**ROLLING MEADOWS/ BULL HILL
LETTER OF INTENT
Sketch Plan Amendment**

September 6, 2023

Matrix Design Group, on behalf of Murray Fountain LLC et al, is submitting a development application for a Sketch Plan Major Amendment for approximately 1,136.9 Acres previously known as the Rolling Hills Ranch Sketch Plan. The original Rolling Hills Ranch Sketch Plan (SKP 05-006) was approved on February 21, 2006 by the El Paso County Board of County Commissioners and subsequently recorded on March 23, 2006 (Resolution No. 06-80). That sketch plan depicted single & multi-family residential, commercial, school sites, parks and open space with a total of 8,577 dwelling units with a mix of densities ranging from 4, 5-8, 8-10, and 12-20 DU/ Acre. Due to several developments within El Paso County named as Rolling Hills the proposed sketch plan amendment will revise the project name to now be known as Rolling Meadows to the north of Bradley Road and Bull Hill to the south of Bradley Road. Rolling Meadows/ Bull Hill is located east of Marksheffel Road, north of the existing Lorson Ranch development, and along both the north and south sides of Bradley Road. The Rolling Meadows/ Bull Hill Sketch Plan

**SKP02**  
SHEET 02 OF 03

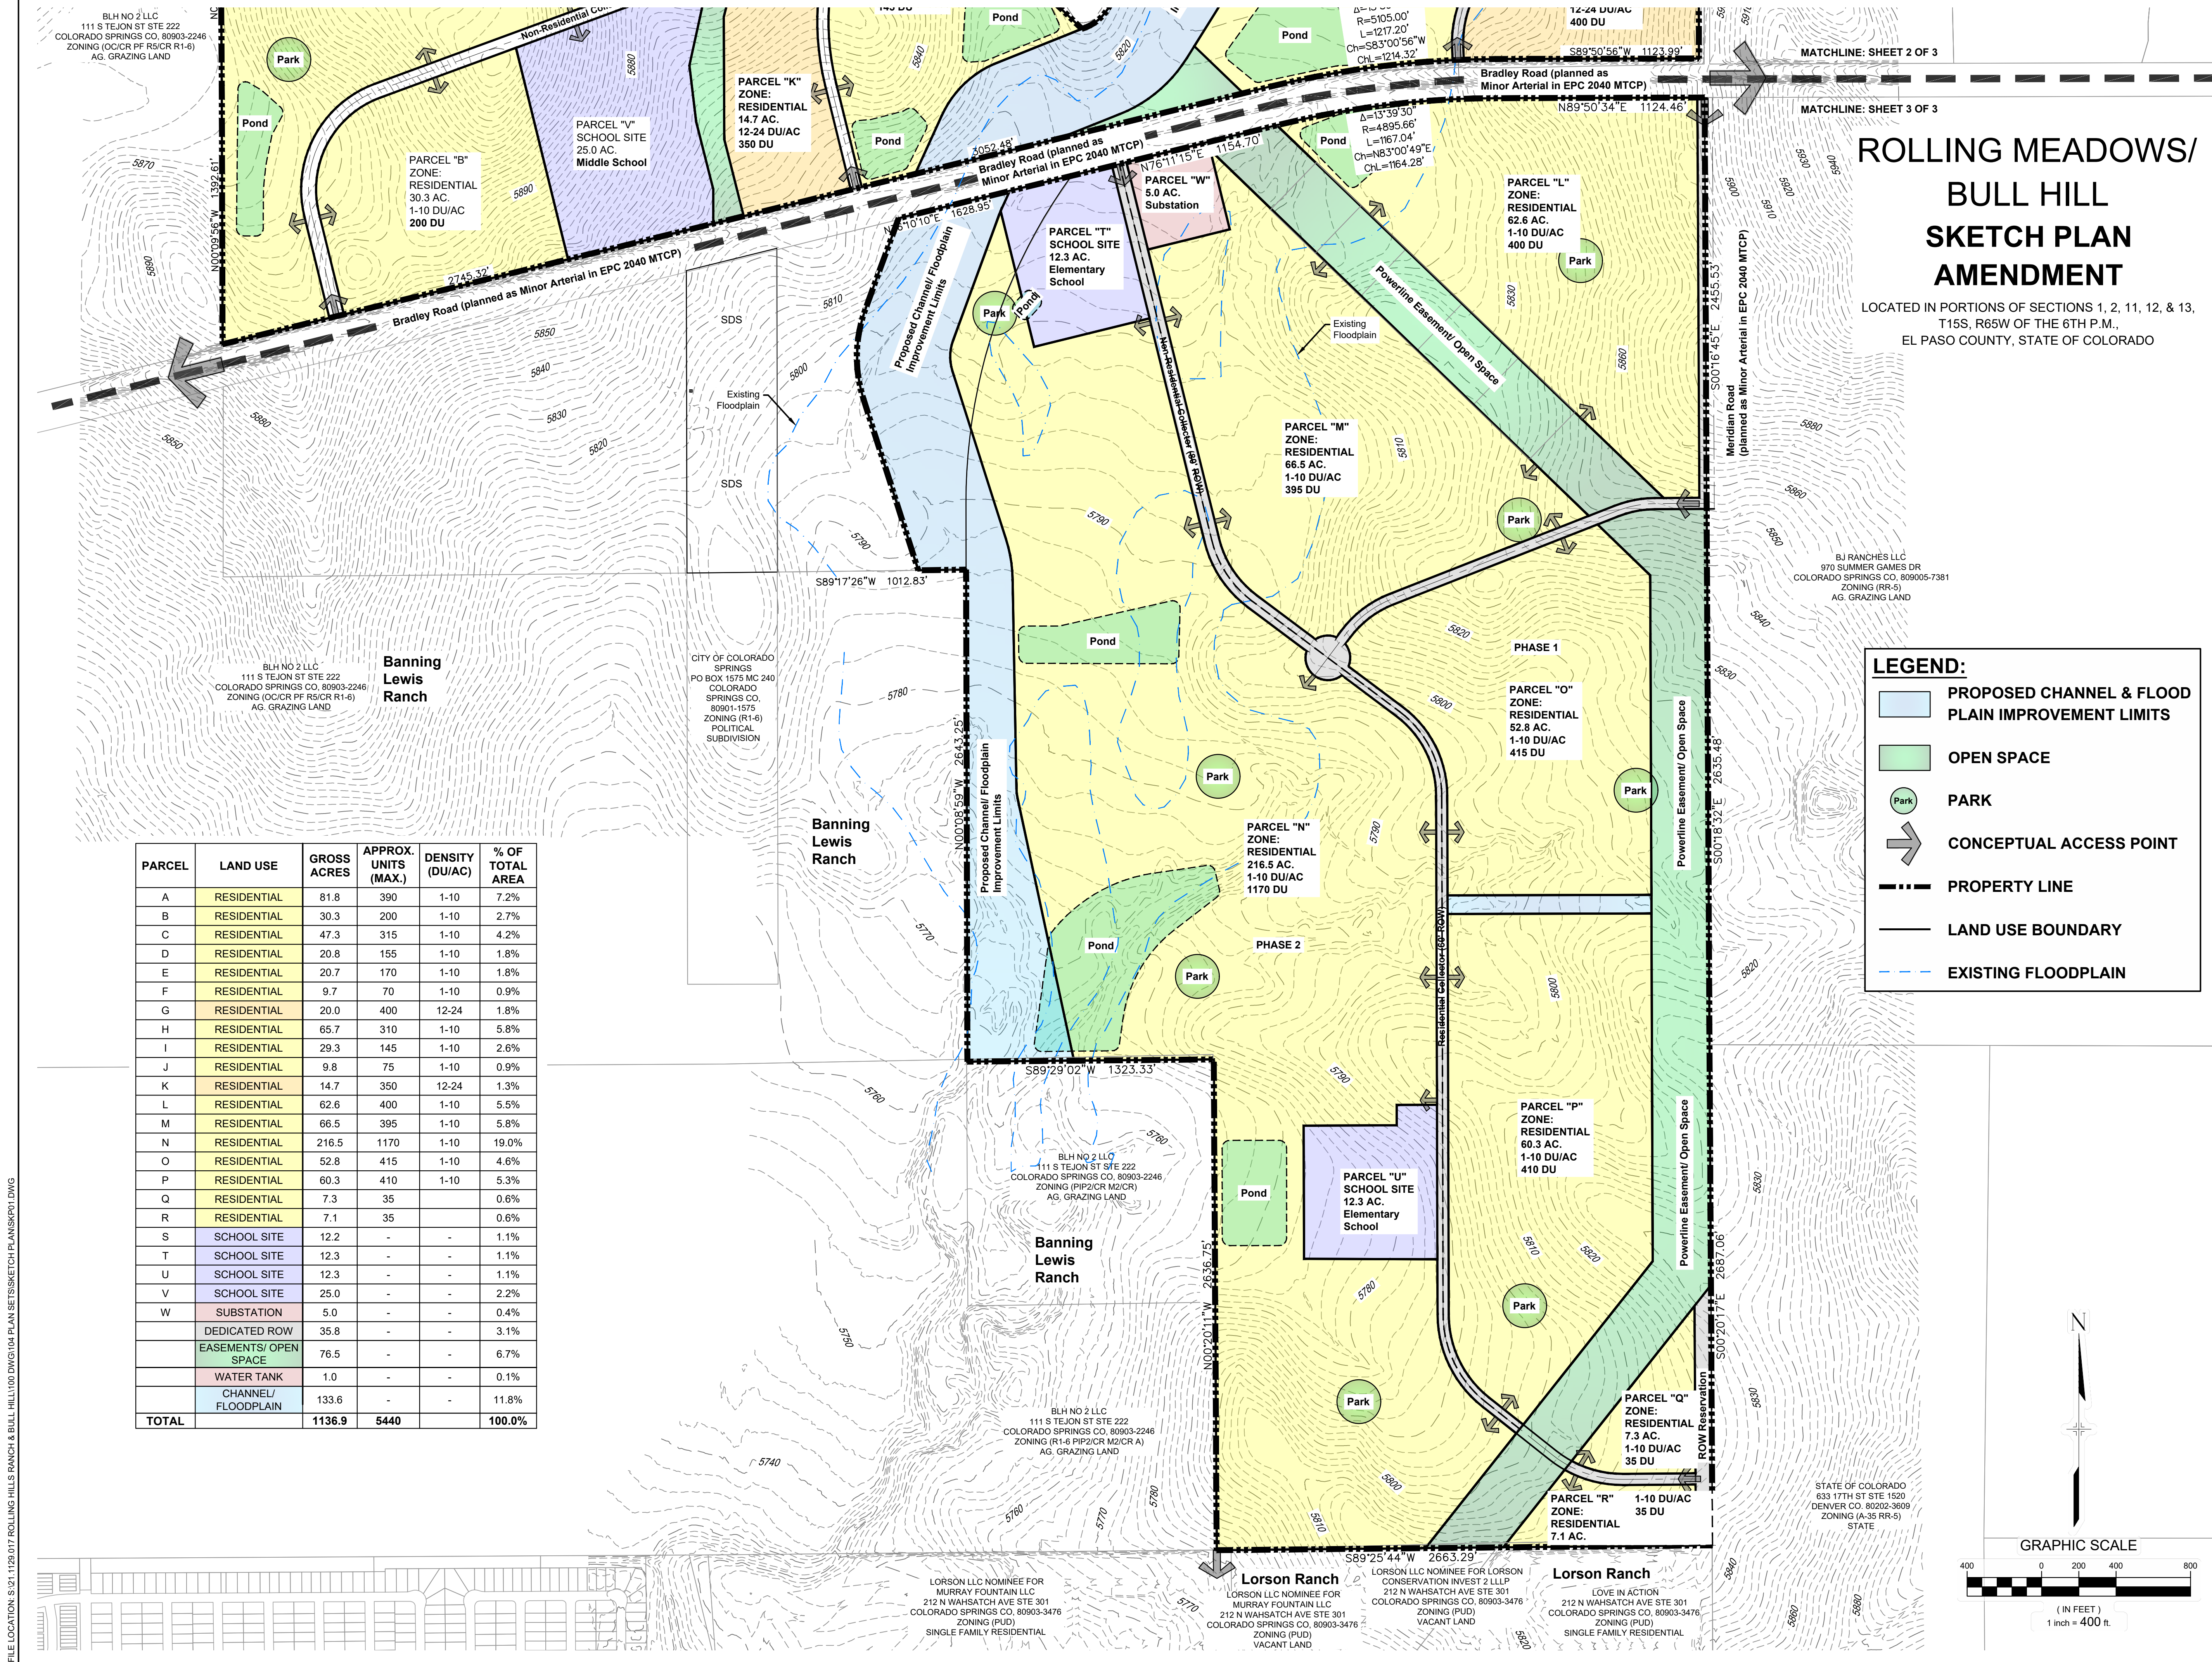
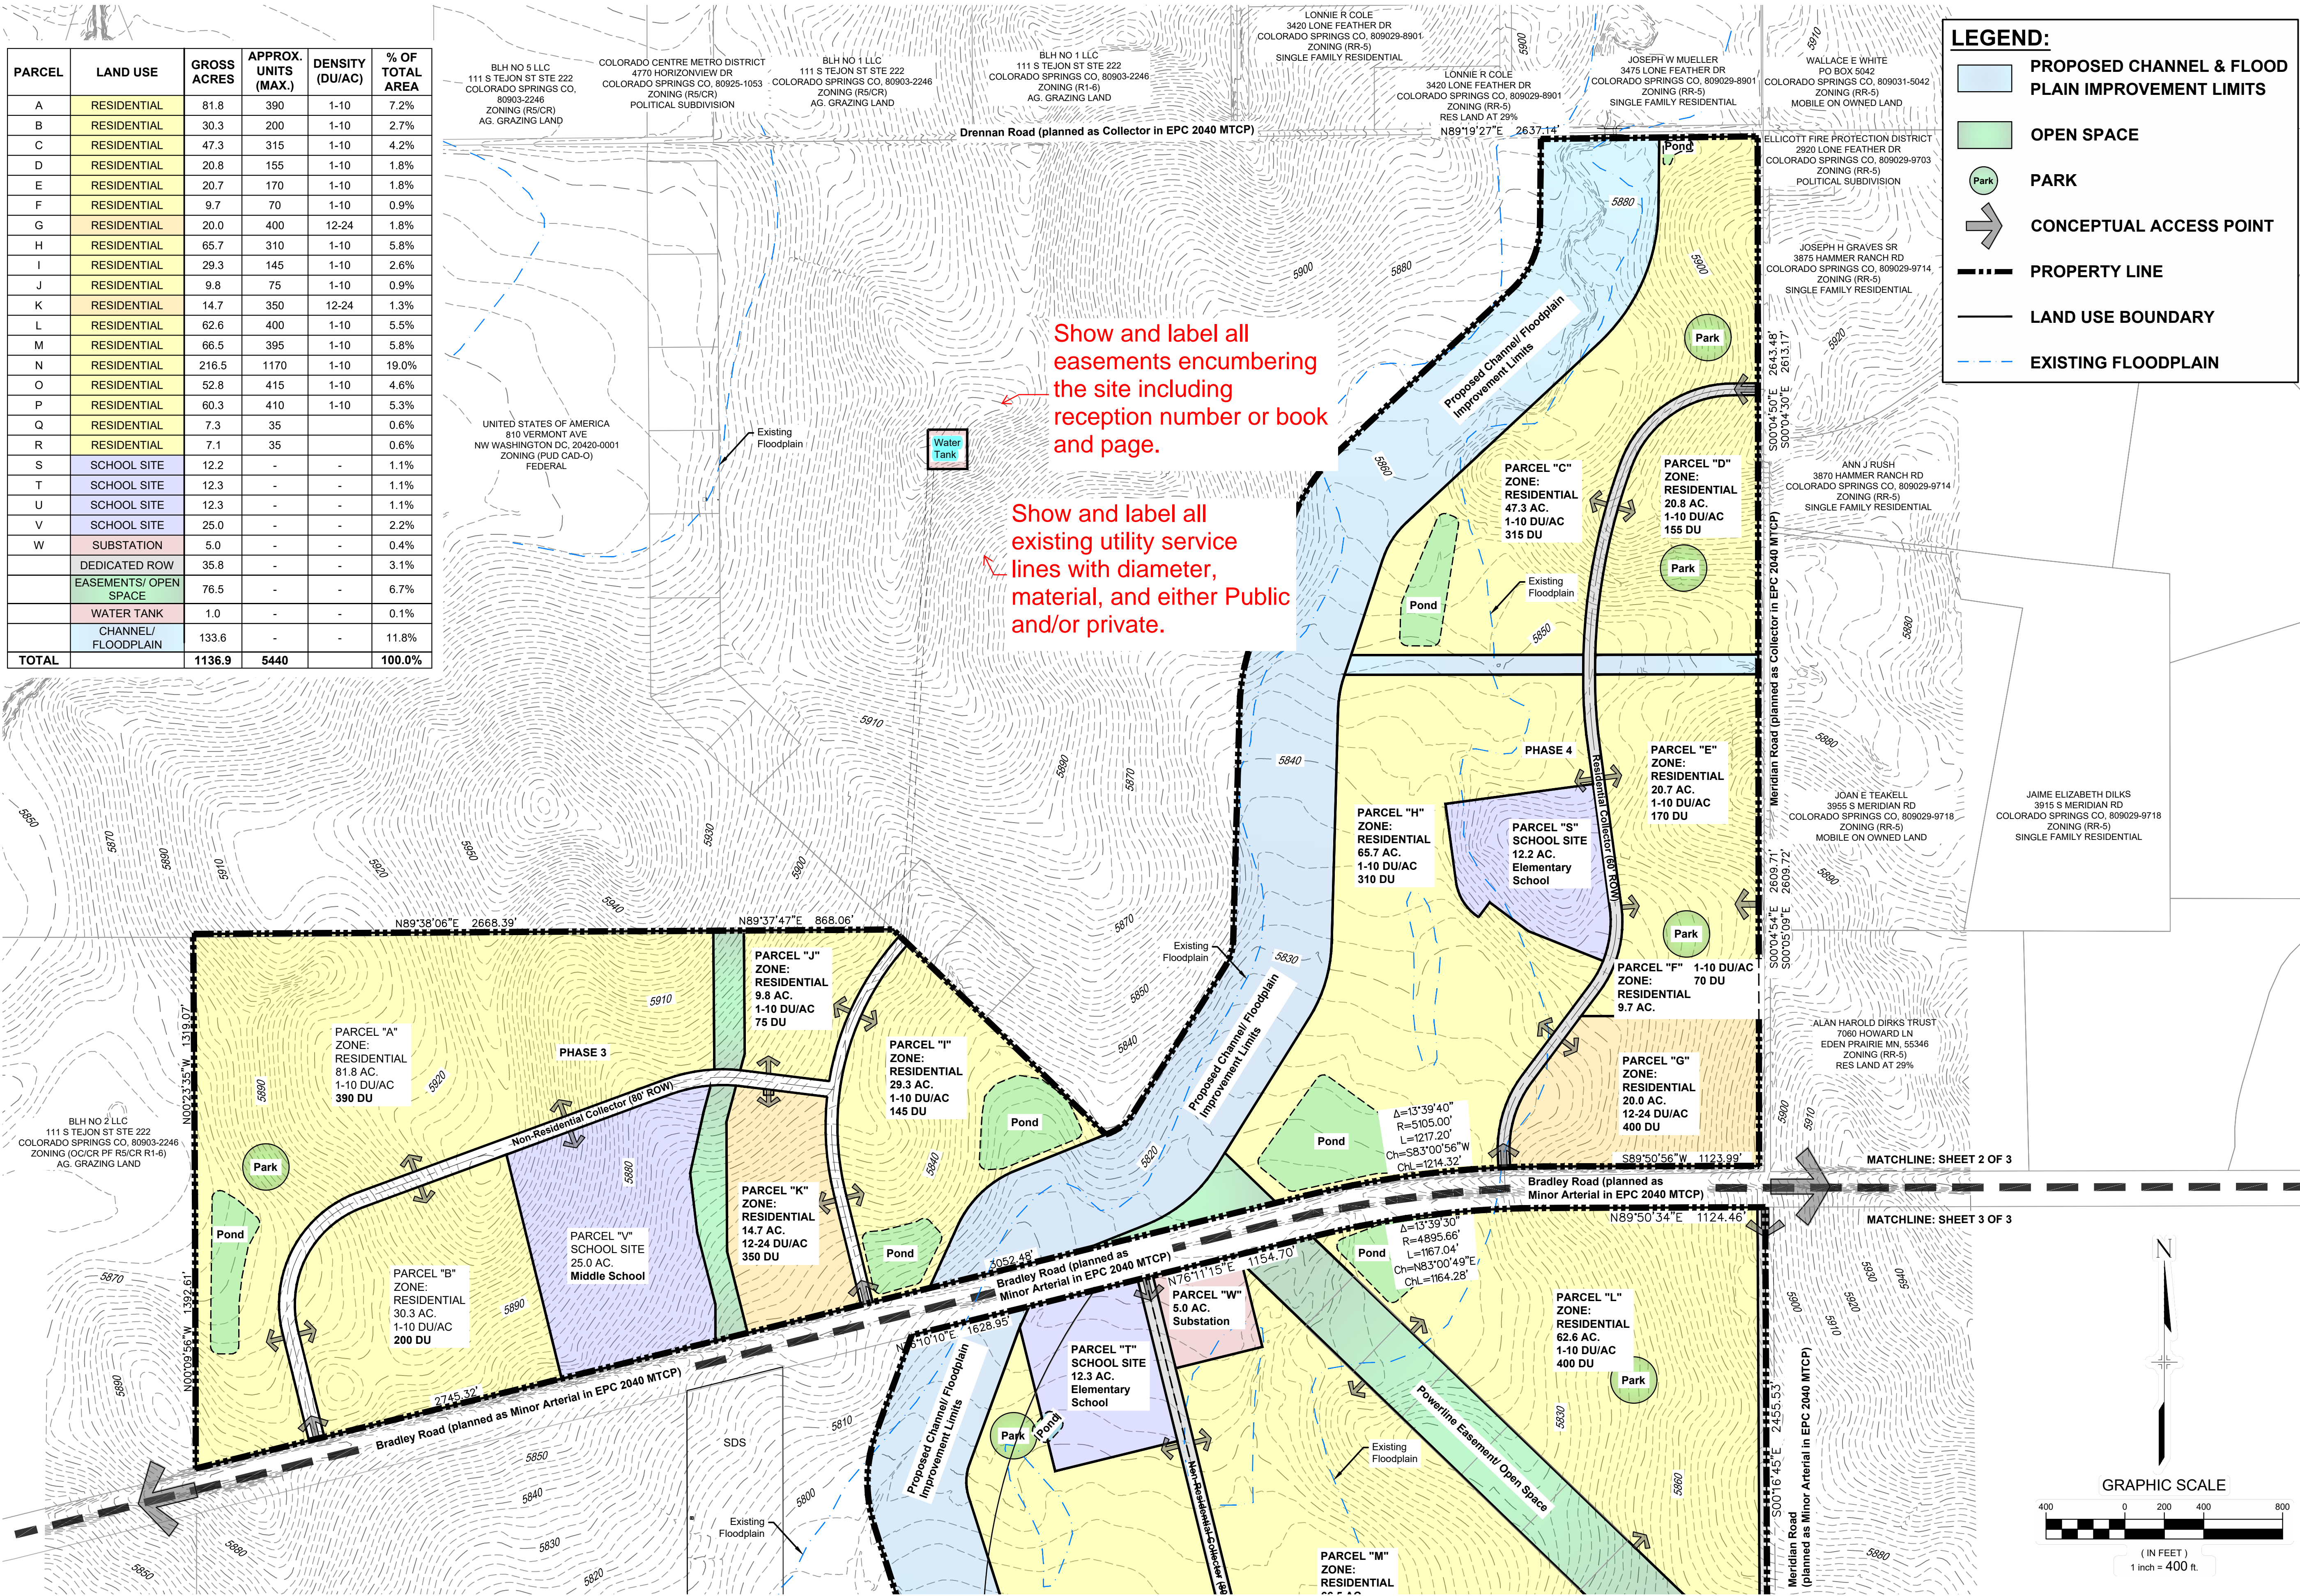
doesn't match sketch plan table total

depict and label these connections. Add trails...

if there are areas you know to be avoided - show them as open land

Commercial uses are supporting land uses in placetype and SKP Plan should incorporate some commercial nodes...

1. *Does the development appropriately include conservation design best practices to protect/preserve existing natural resources?*
Future, more detailed design submittals will illustrate implementation of any conservation best practices such as clustered development, inclusion of parks/ open space, and preservation of natural areas. depict on SKP

this is the first mention of a fire station. identify on table and SKP.
